Application for a Non-Material Amendment Following a Grant of Planning Permission

Variation of Condition No. 2 (approved plans) pursuant to 14/01324/FUL to allow for an increase in height of approved extension

14/01324/FUL and 17/02940/VAR

Installation of PV Solar panels.

PROPOSED FLOOR PLANS

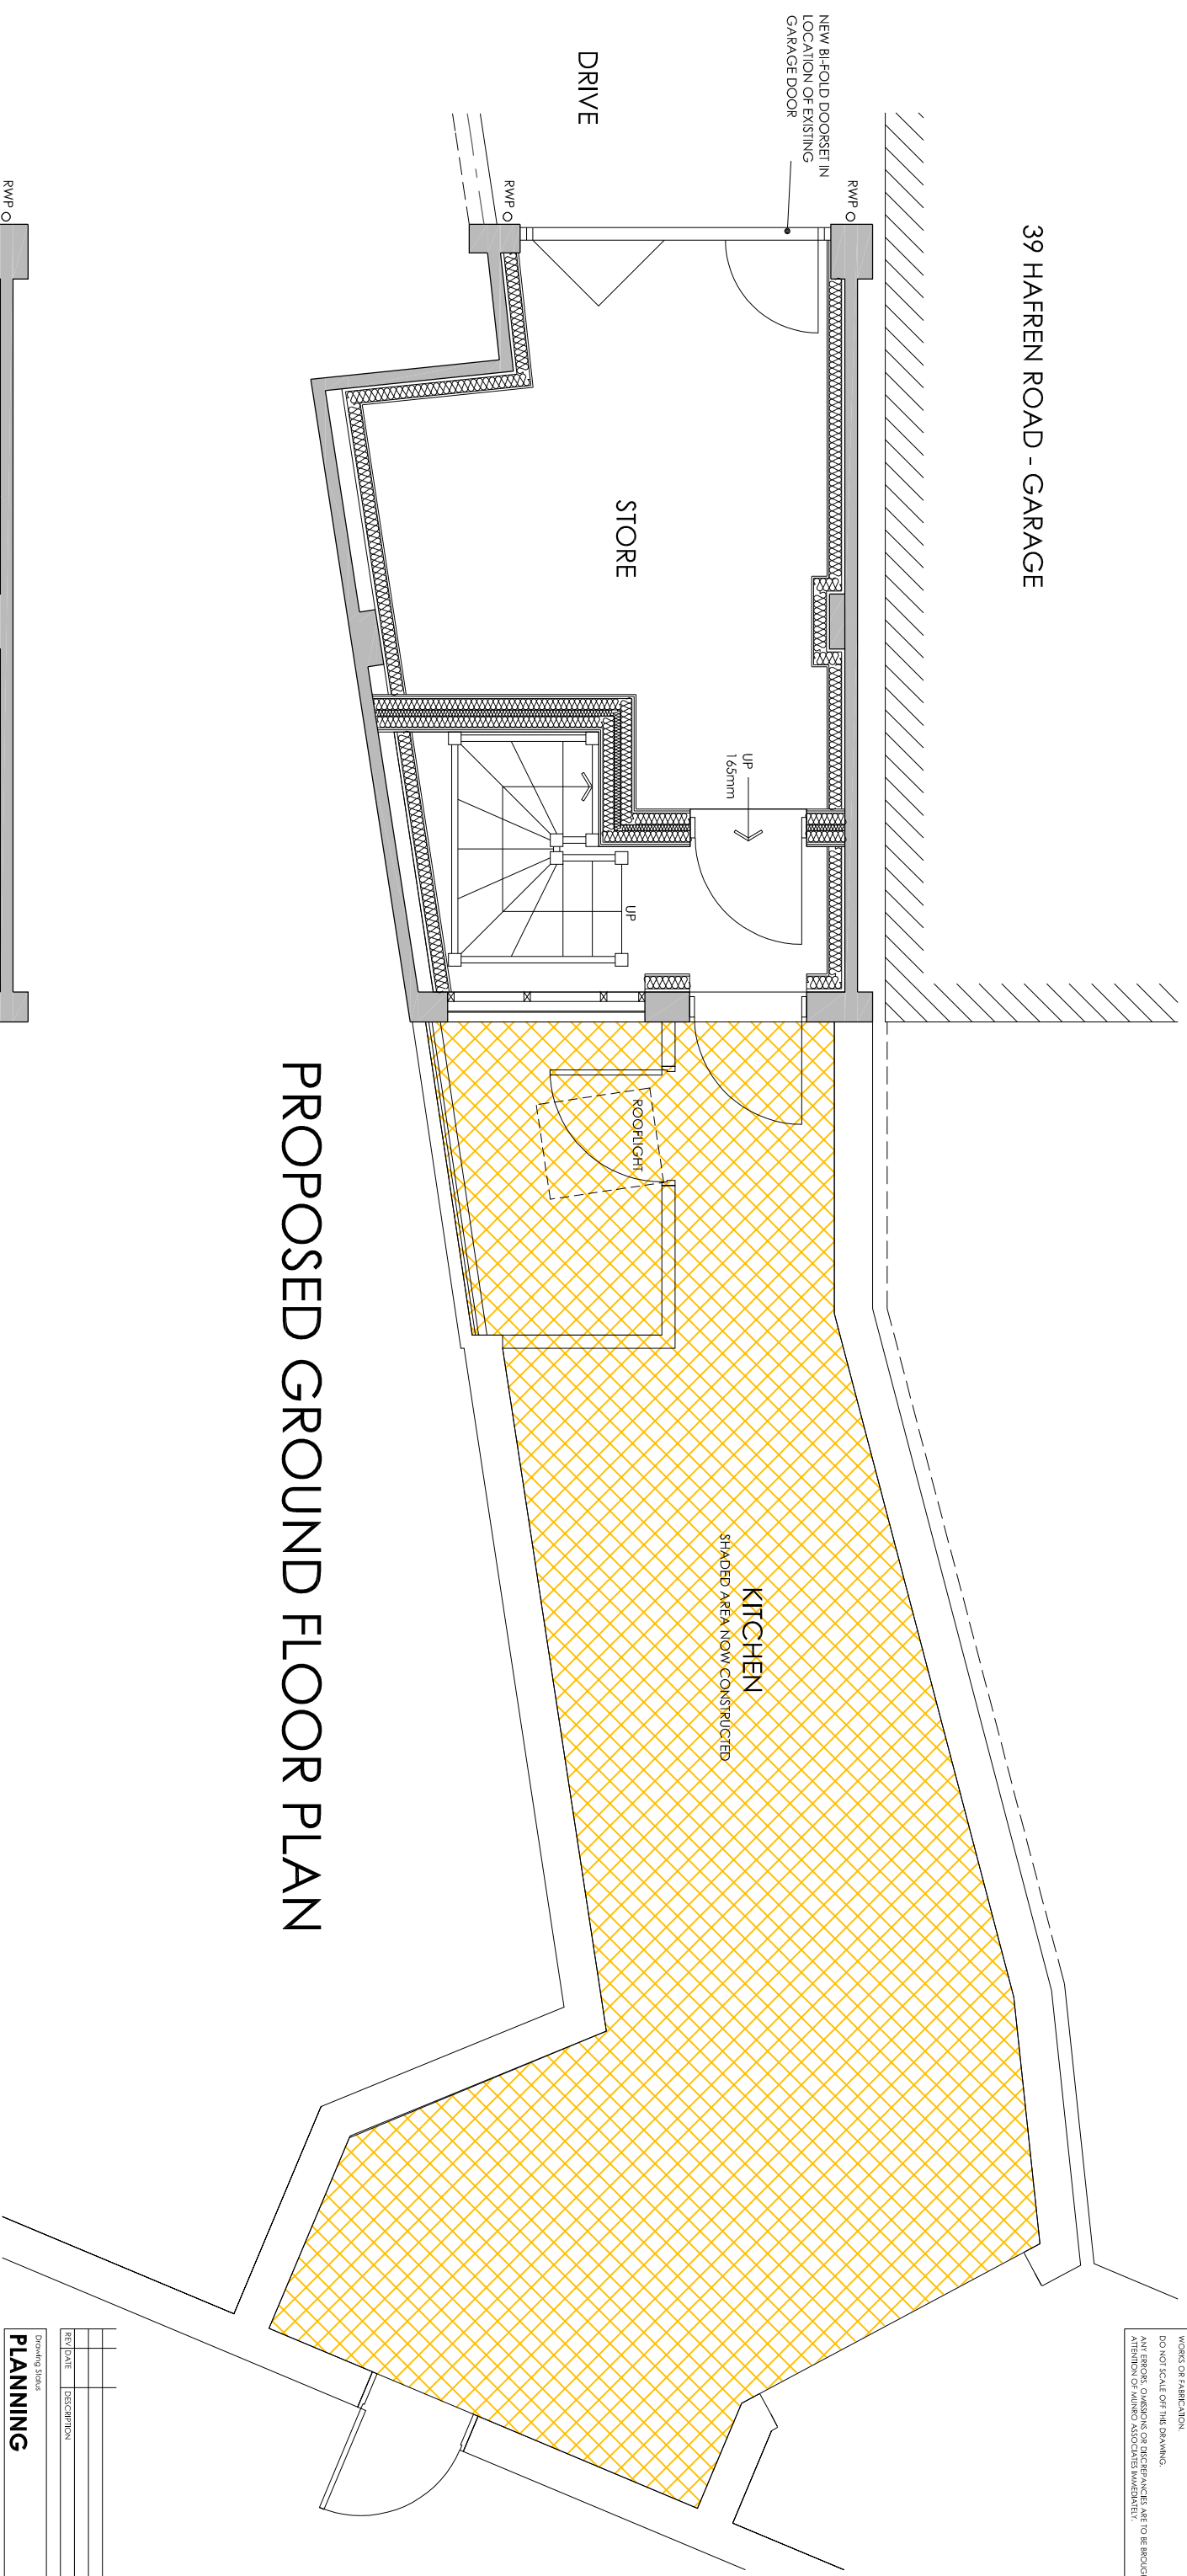
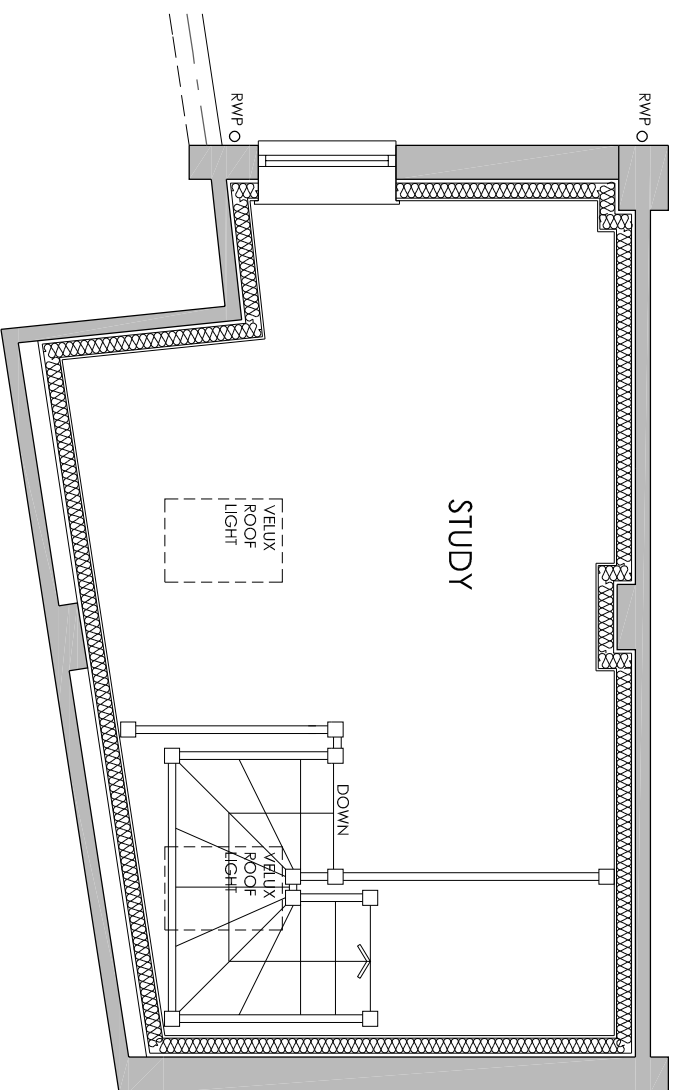
Change to eaves height of building by reducing roof pitch. (No increase to Ridge Height).

Change to materials.

PV panels to provide a more sustainable build.

Eaves height change to provide slightly more headroom / usable space to the first floor Study.

Material change to allow for easier construction on boundary lines.
